Application number: 2020/91215	
What is the application for?:	Outline application for erection of residential development
Address of the site or building:	Land at, Green Acres Close, Emley, Huddersfield, HD8 9RA
Postcode:

PLANNING APPLICATION 2020/91215 Note 23/05/20

Land at Greenacres Close, access from Wentworth end.

1. VEHICLE SPEED SURVEY (11/03/21):
85th PERCENTILE WET WEATHER SPEEDS:
EASTBOUND 30.4 MPH (49 KPH) – 41.3m MFS2
WESTBOUND 31.9 MPH (51 KPH) – 44.4m MFS2

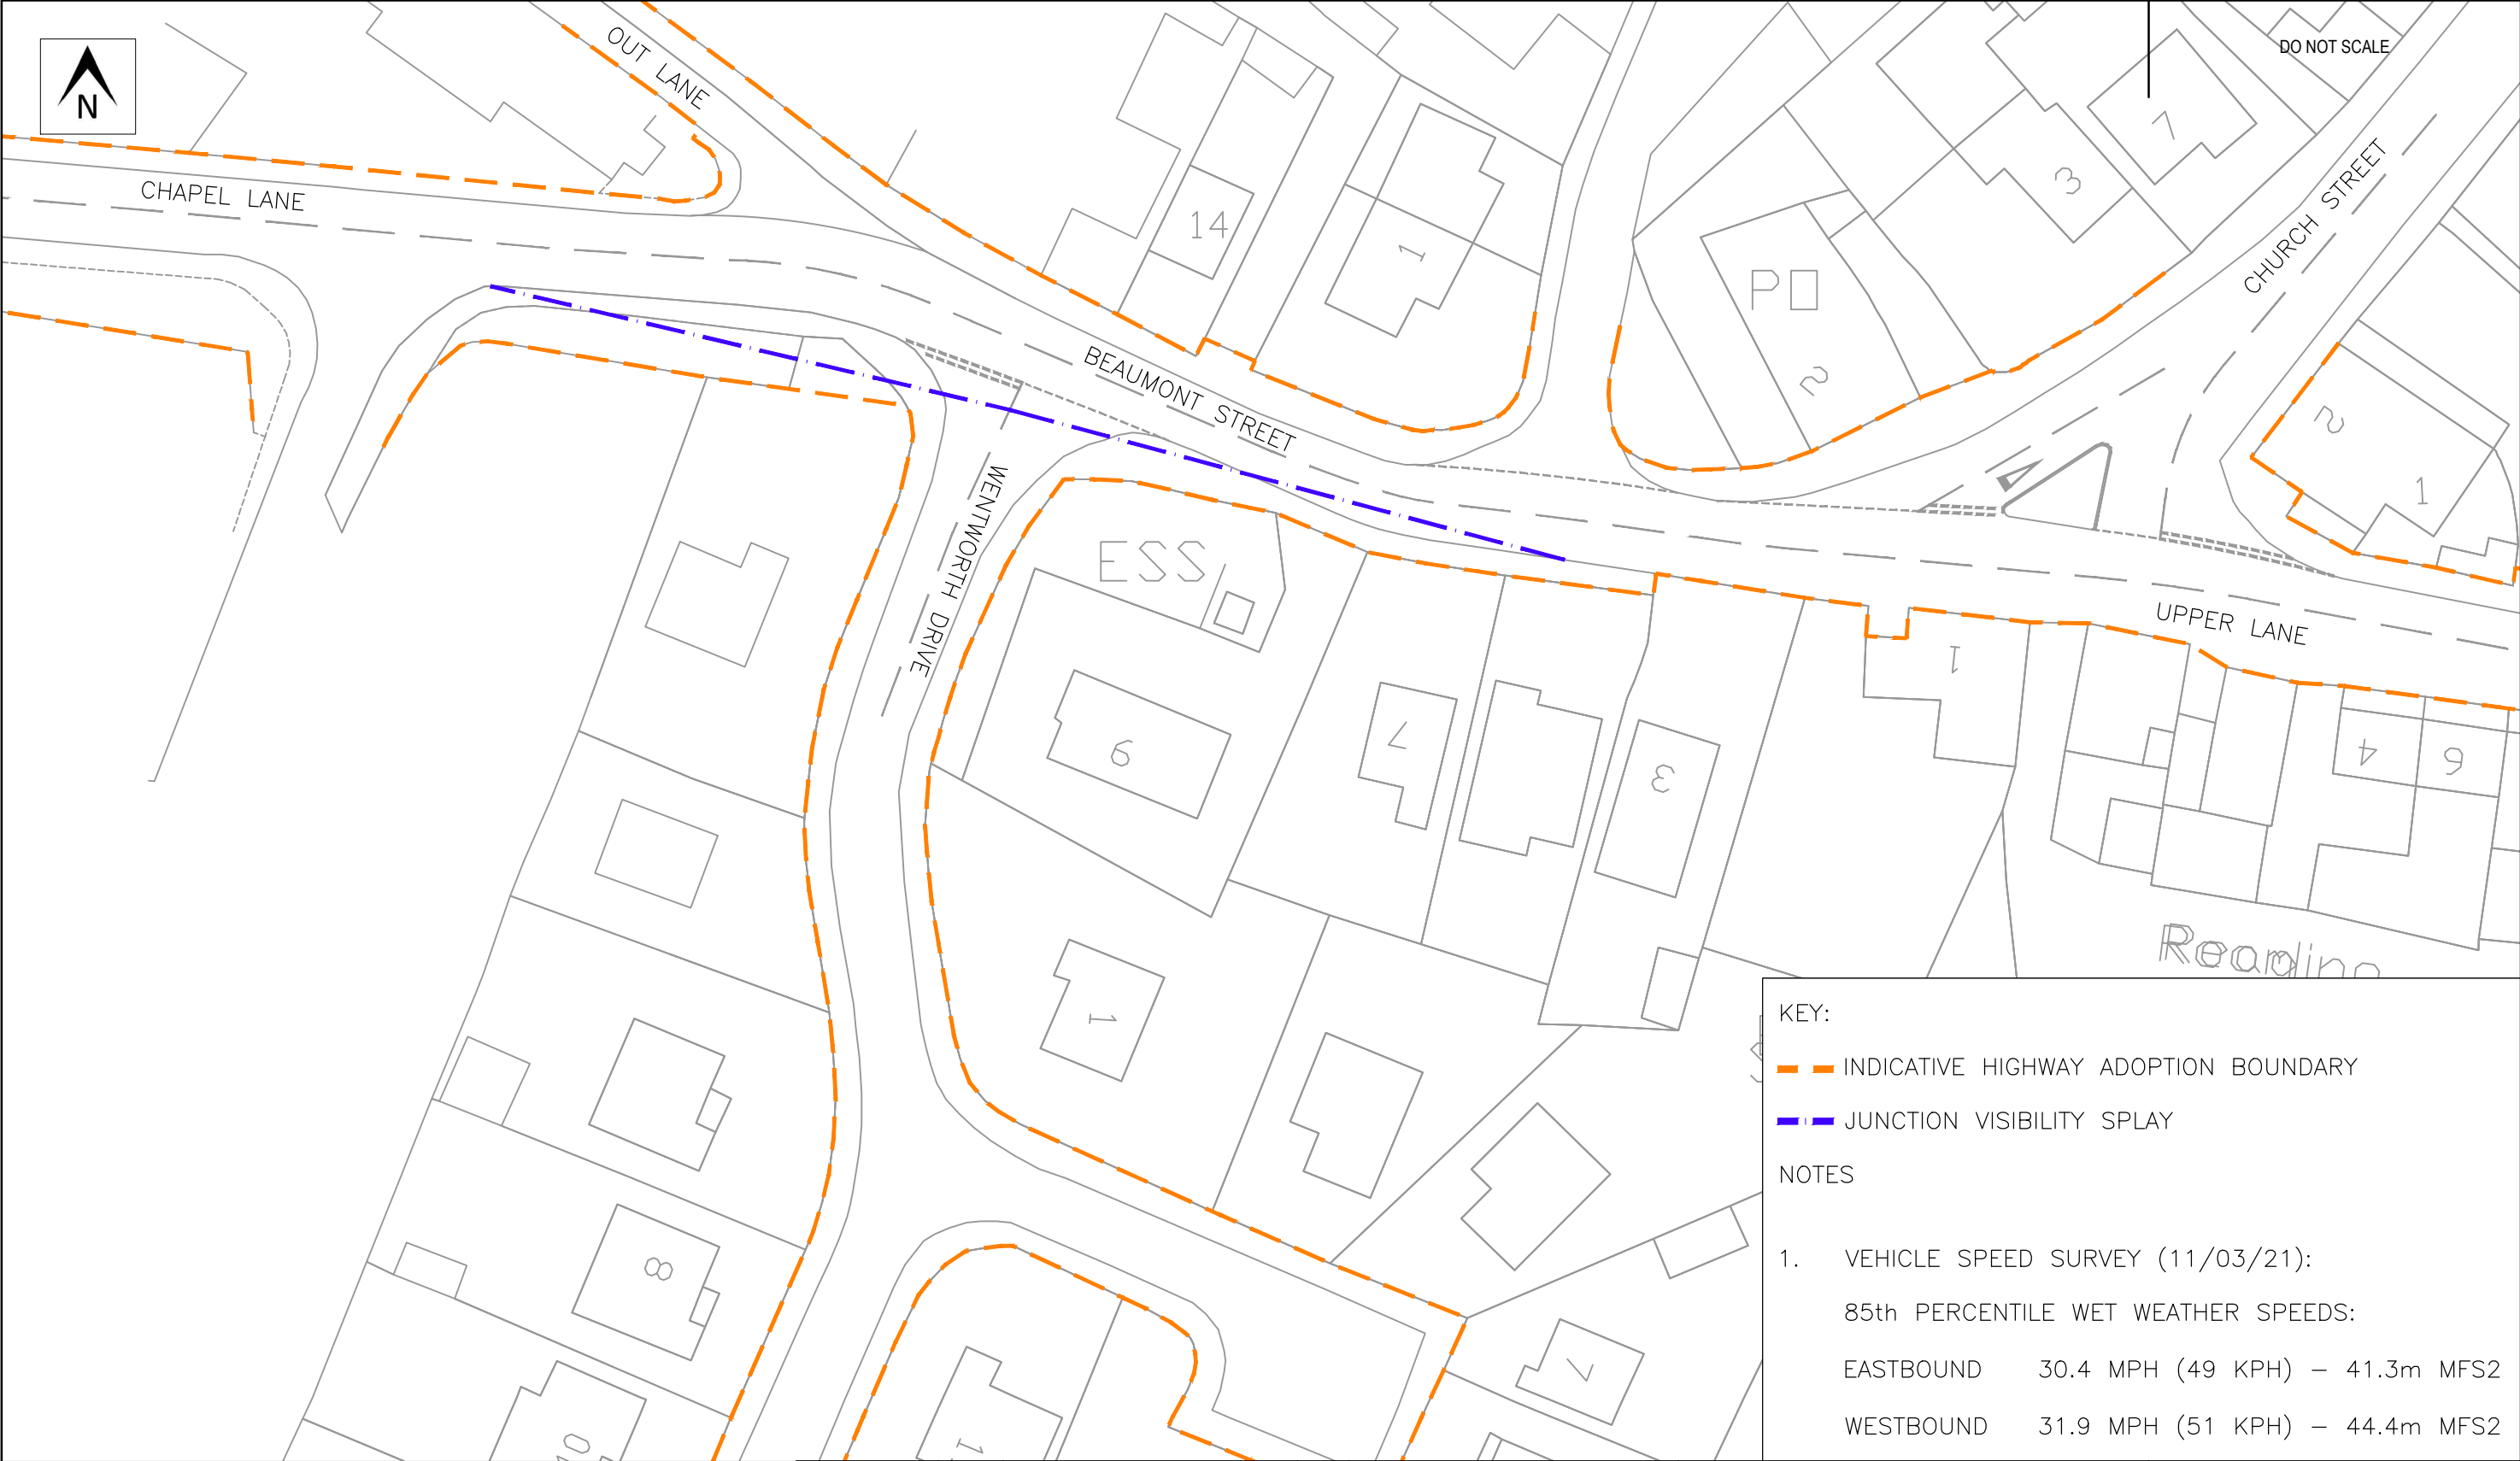
3. The previous application fell short of highway required standards of safety and related issues, and if those required standards still apply, the new application will surely fail for the same reasons. The situation at the junction of Wentworth Drive and Beaumont Street is, if anything, more dangerous than the junction of Warburton and Upper Lane.

4. Exiting from Wentworth Drive on to Beaumont Street poses more difficulties than Warburton . Simply standing at the junction it is obvious how many pairs of eyes are needed to effect a safe vehicle exit.

8. Parked vehicles opposite Wentworth Drive force traffic turning right out of Wentworth Drive, (eastwards) to pass over the wrong carriageway facing oncoming traffic. This is virtually a permanent situation.

9. Tyburn Lane is a few steps away to the west causing problems and the bus stop is now situated near the entrance to Wentworth Drive, having been moved from opposite The White Cross. This aggravates the situation at this junction.
